CITY OF ALBUQUERQUE

**Re: Bank of Albuquerque, Ventana Ranch Grading and Drainage Plan
Engineer's Stamp dated 2-20-08 (B10-D8B)**

SHEET:  
**C-101**

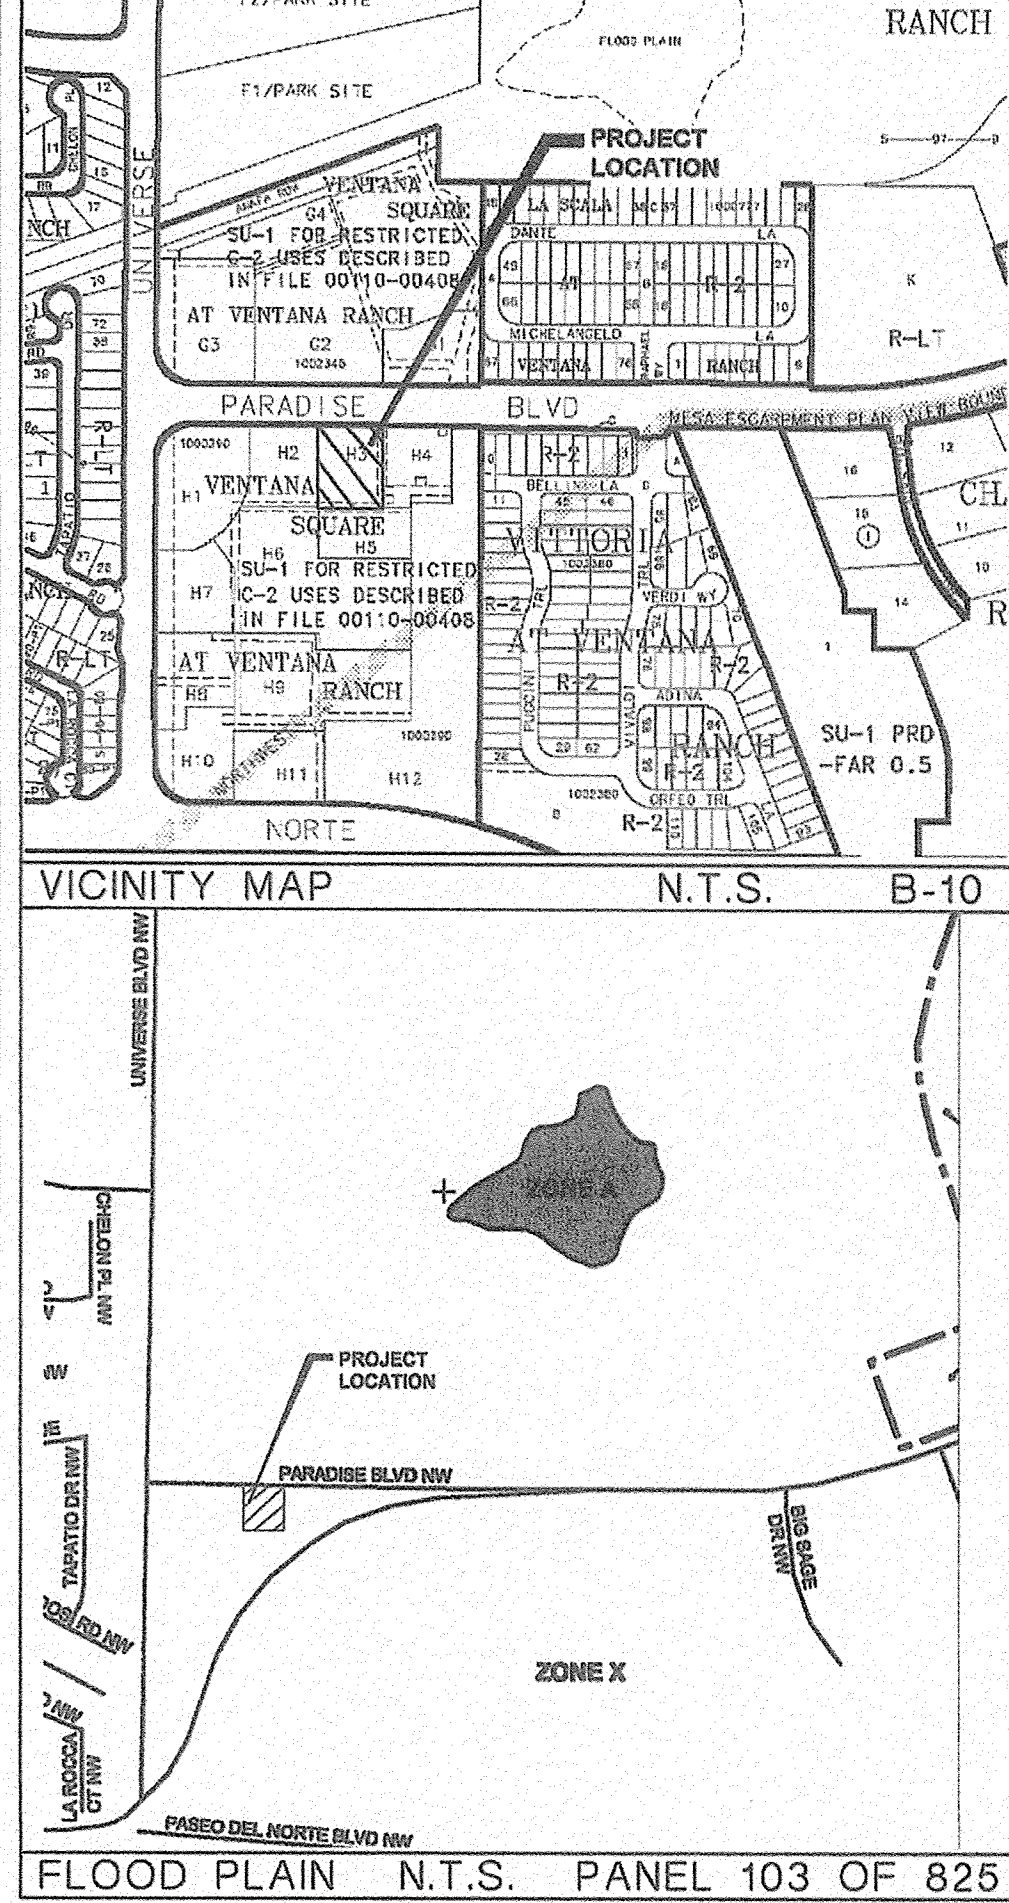
- A revised calculation adequately showing that most of the site will be paved or rooftop will be required.
- Engineer Certification of the grading plan per the DPM checklist will be required.
